About the application

Application number: 2023/91413	
What is the application for?:	Outline application for erection of residential development
Address of the site or building:	adj, 25, Richmond Avenue, Fartown, Huddersfield, HD2 2QH
Postcode:	HD2 2QH

3. Proposed Site Layout

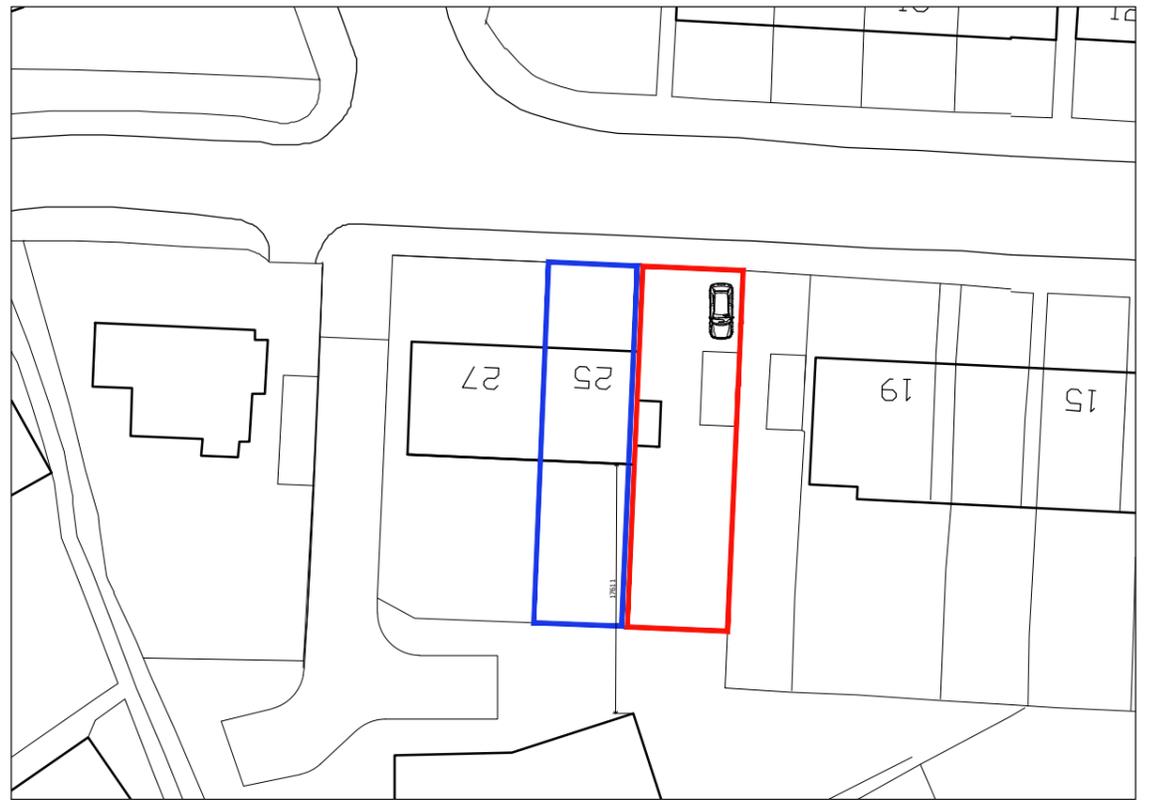
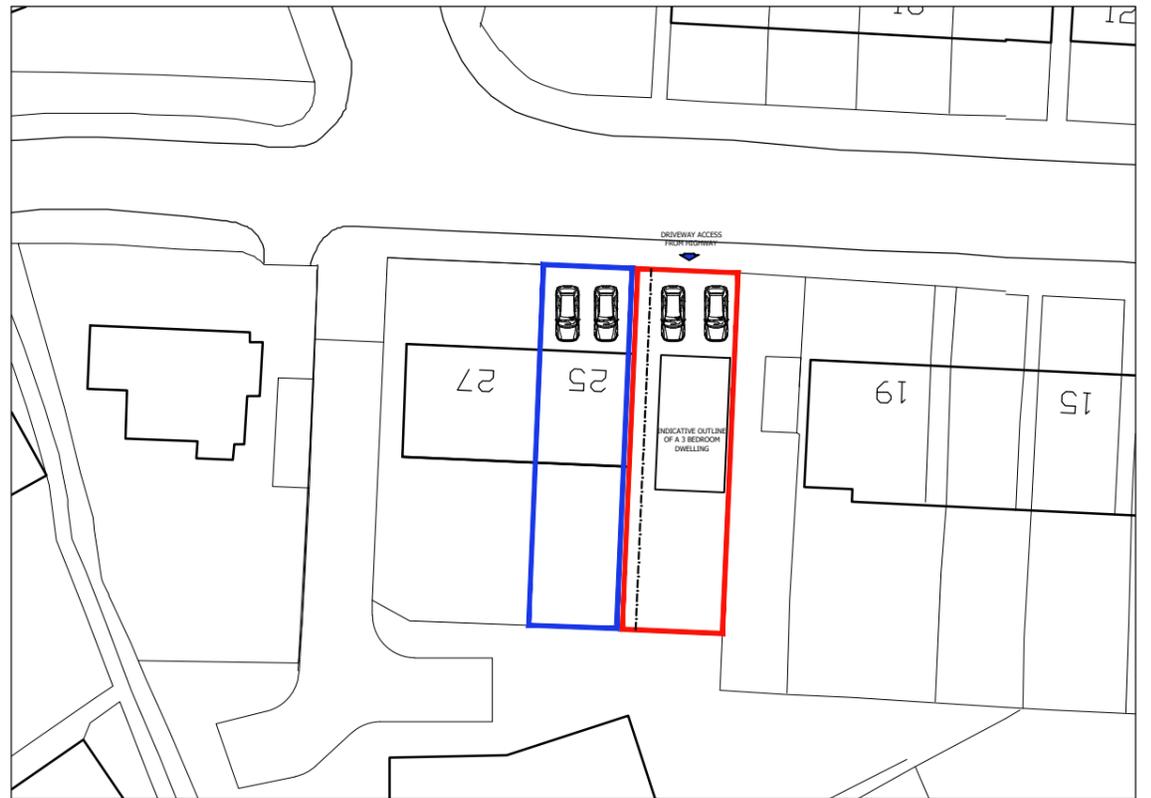
Type of comment: An objection	
Do you wish your comments to be published on the website anonymously?	Yes
I walk past this site every day and the parking on this street is horrendous parking all the car in a row will give the effect of a car park and not a driveway Surely the site is too small for a detached house and the people who live in number 19 will be looking out of there bedroom window onto a gable wall that is far too close to the window and under minimum permitted distances
